From: Reinah Urqueza <RUrqueza@cityofsydney.nsw.gov.au>
Sent: Wednesday, 15 July 2020 12:42 PM
To: Megan Fu
Cc: Andrew Rees
Subject: RE: SSD 7539 - Darlington Terraces Mixed Use Development

In response to the RTS and as per the letter dated 2 July 2020, the City maintains objection to proposal on the grounds detailed in our previous letter dated 15 June 2018. To summarise, the following issues are reiterated:

PROPOSED SHADOW DIAGRAMS - UNIT 120 (JAN-MAR)

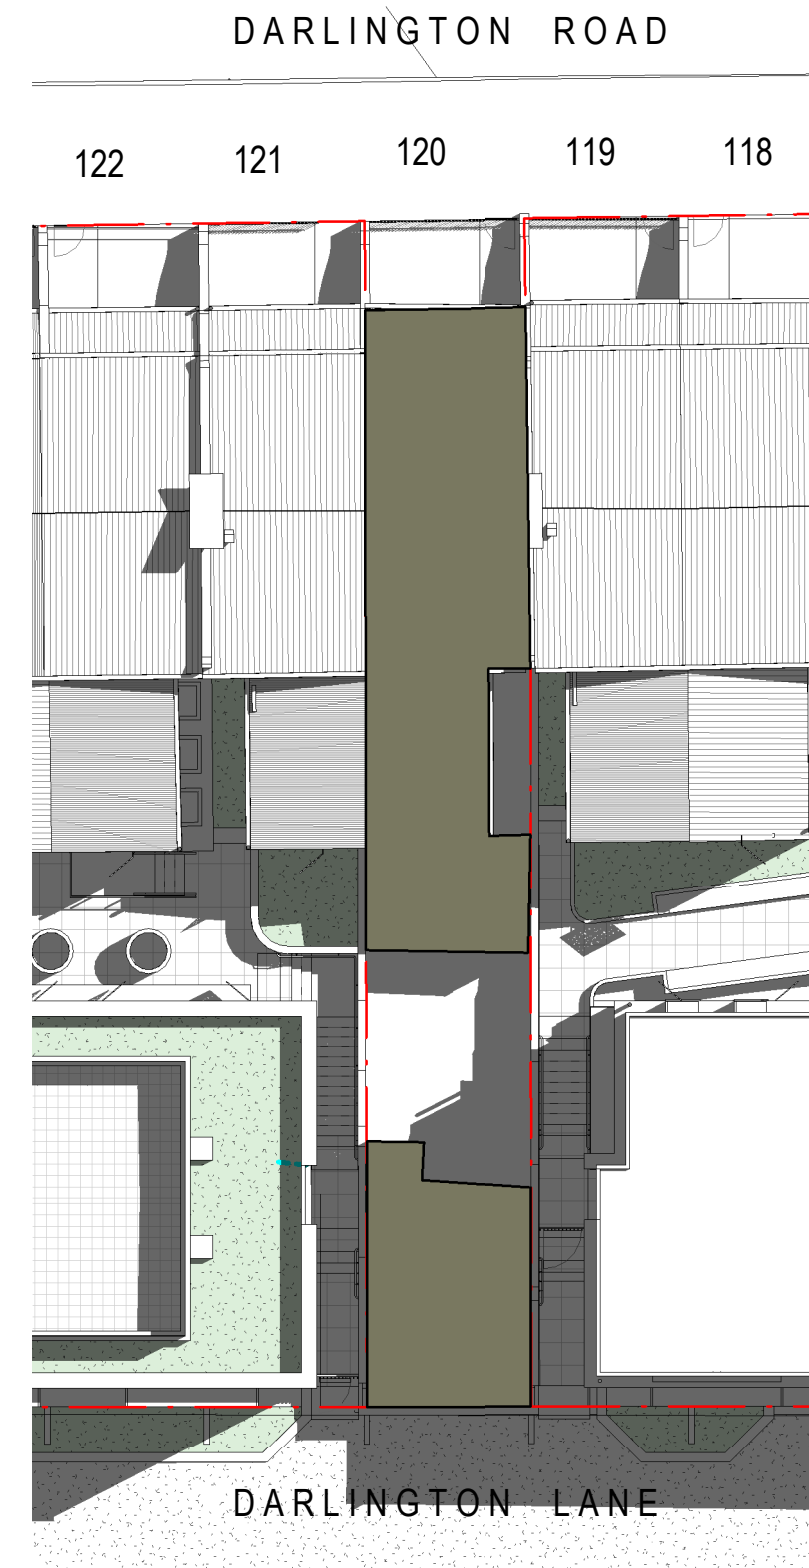
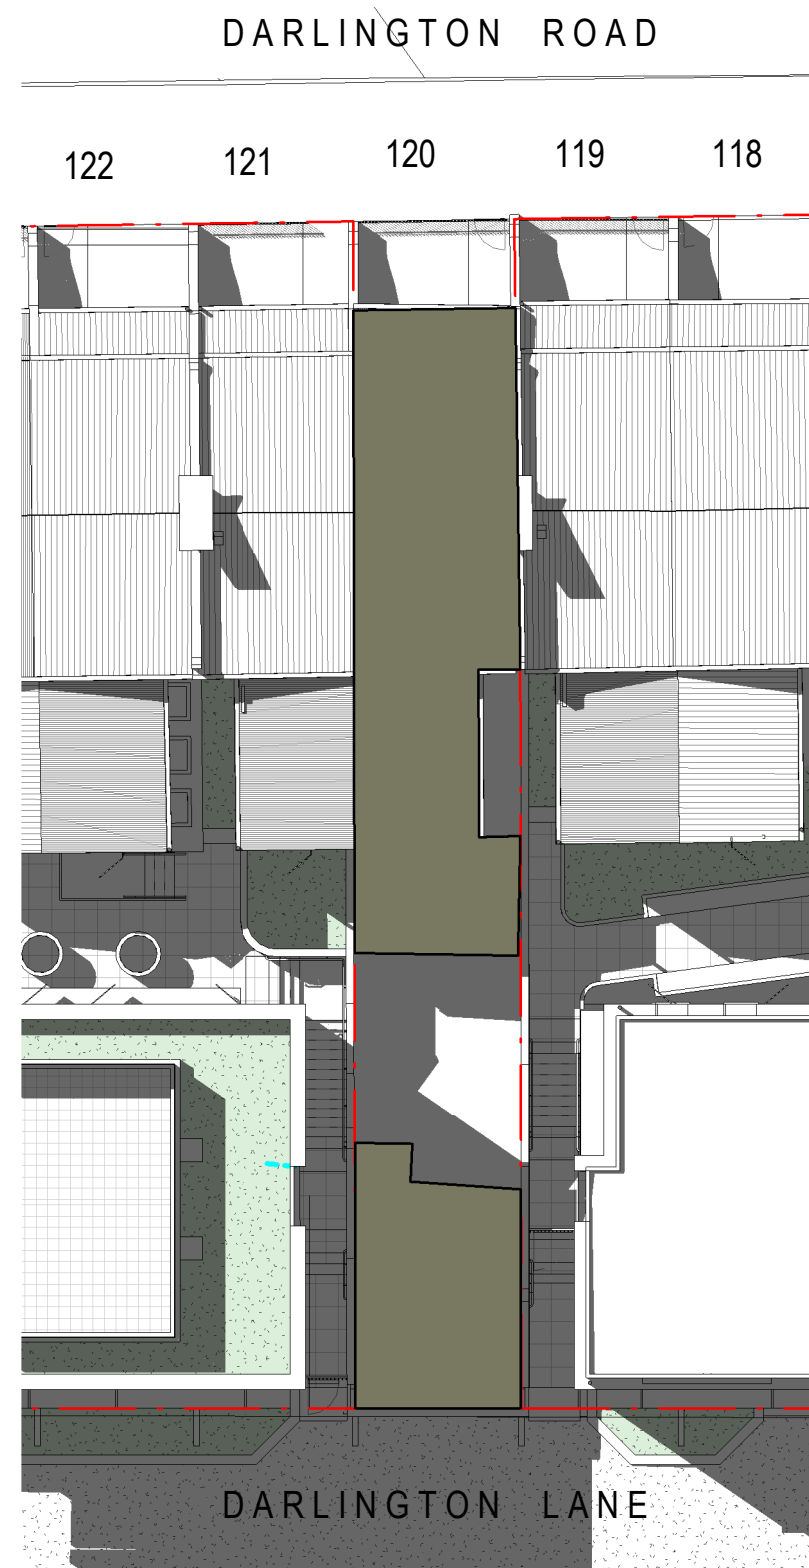
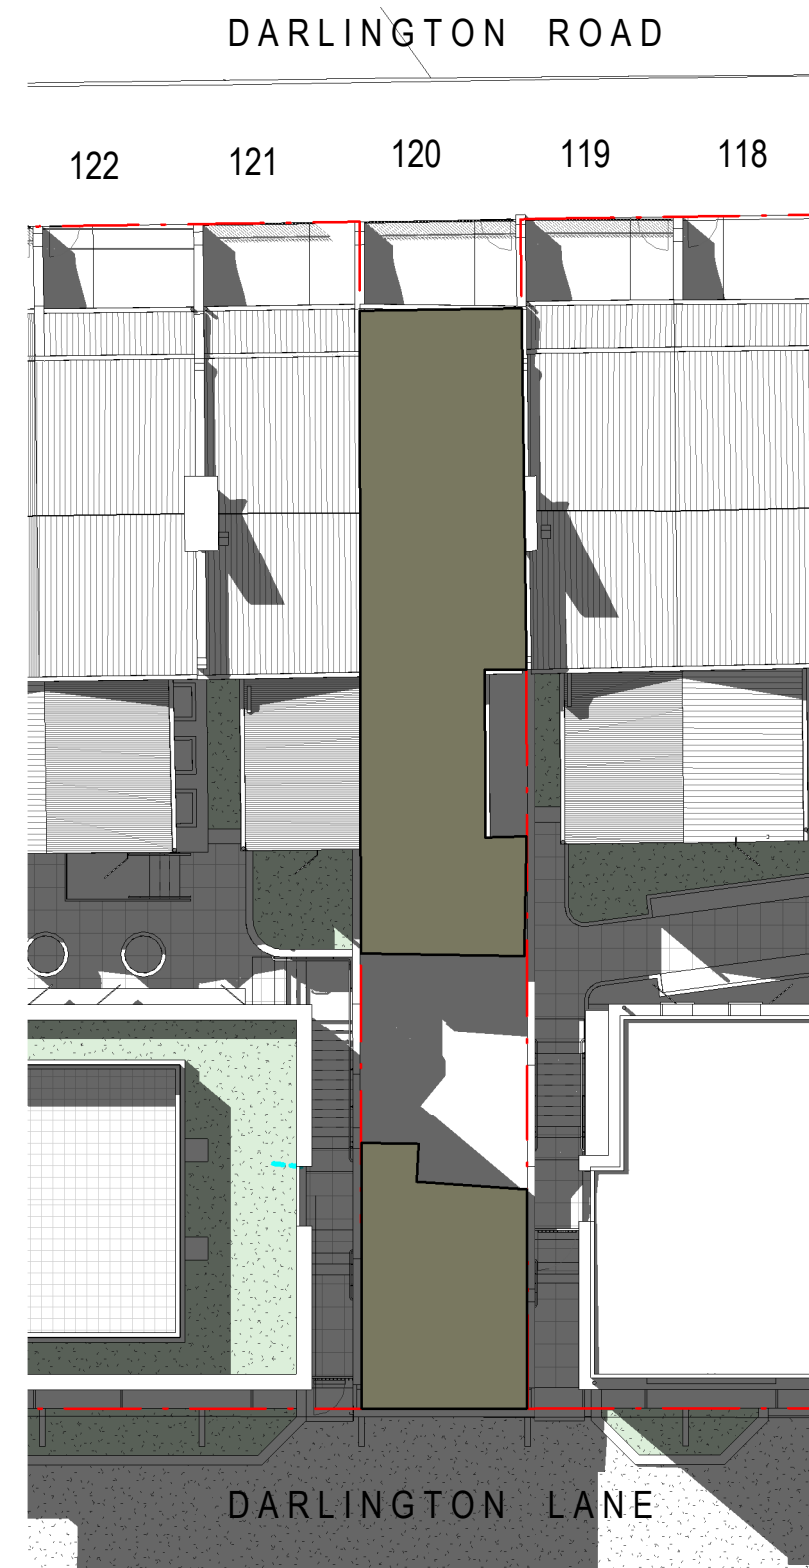
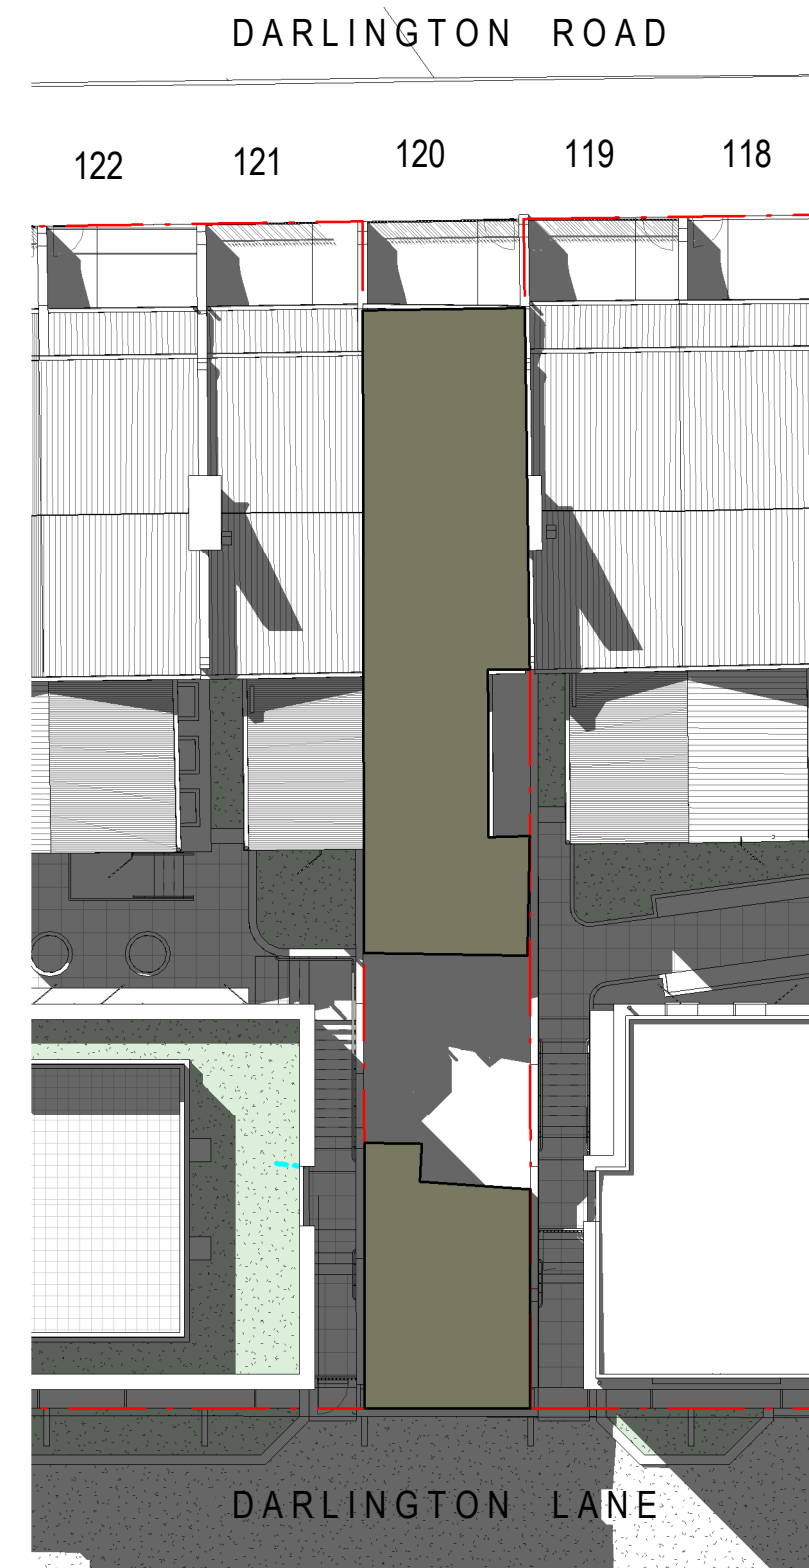
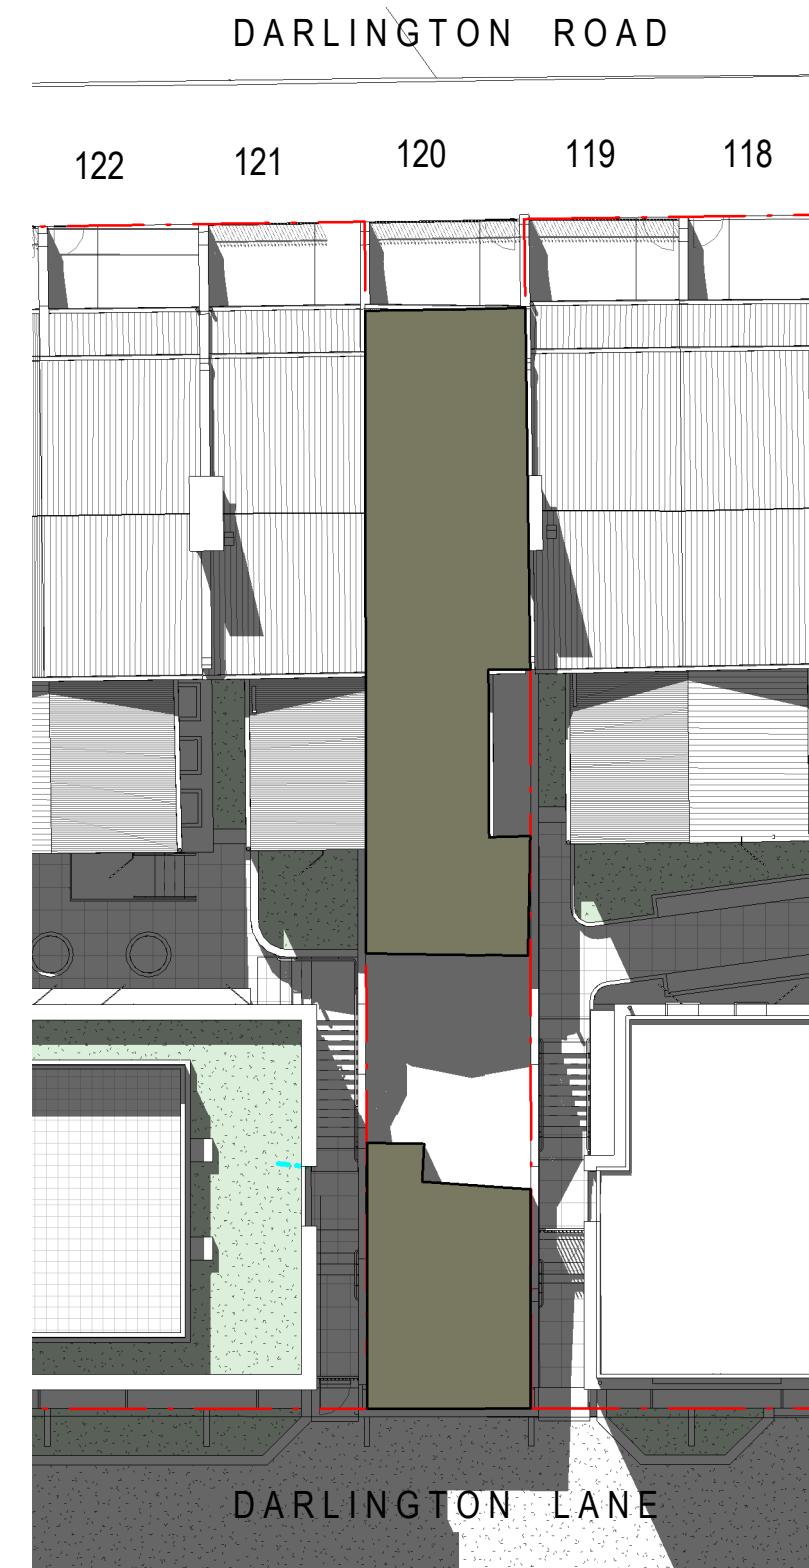
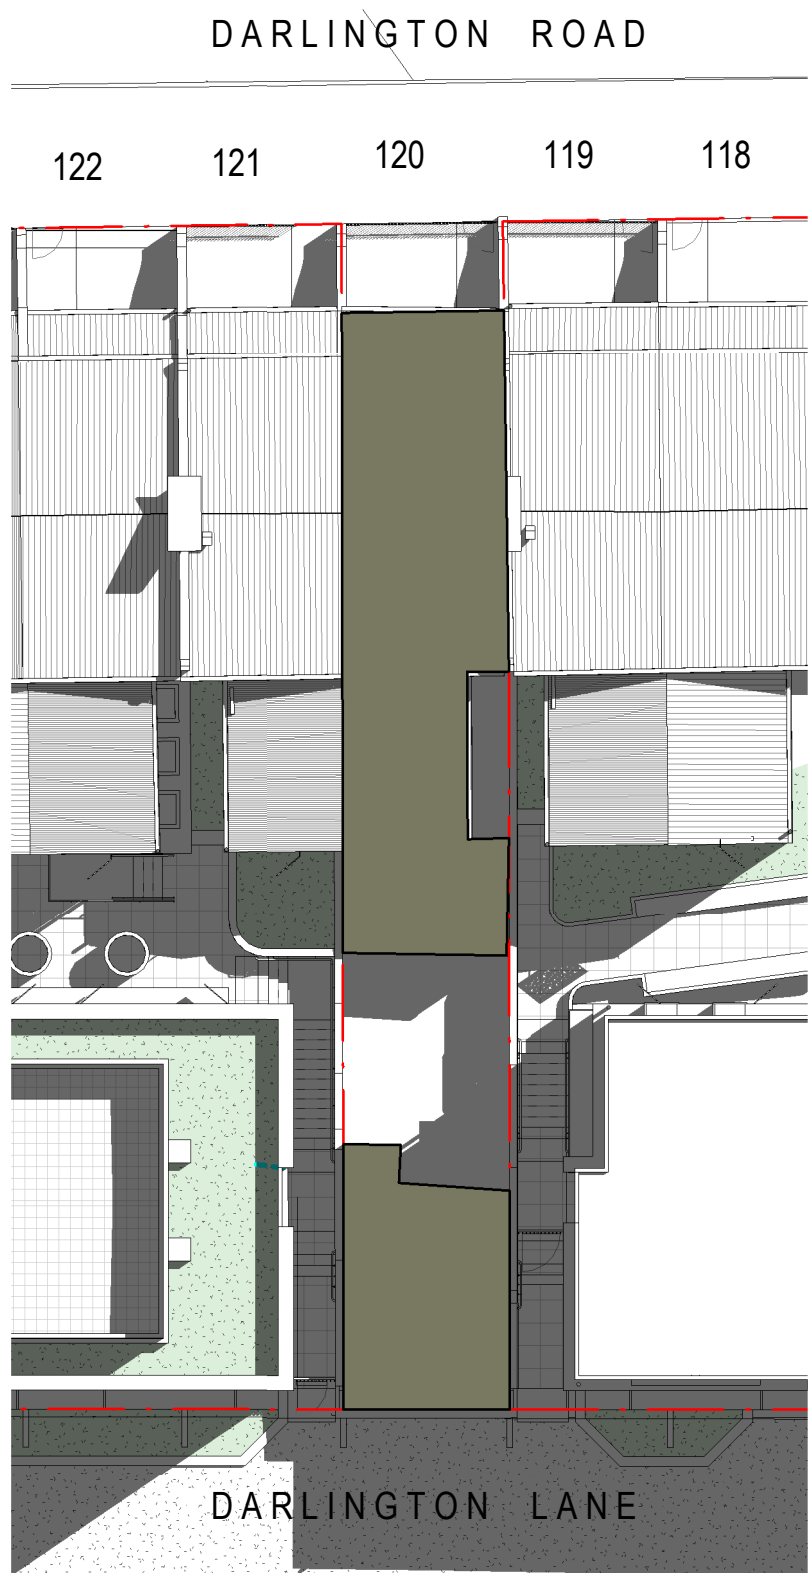
6. Shadow diagrams showing hourly impacts to 97 and 120 Darlington Road have not been provided.
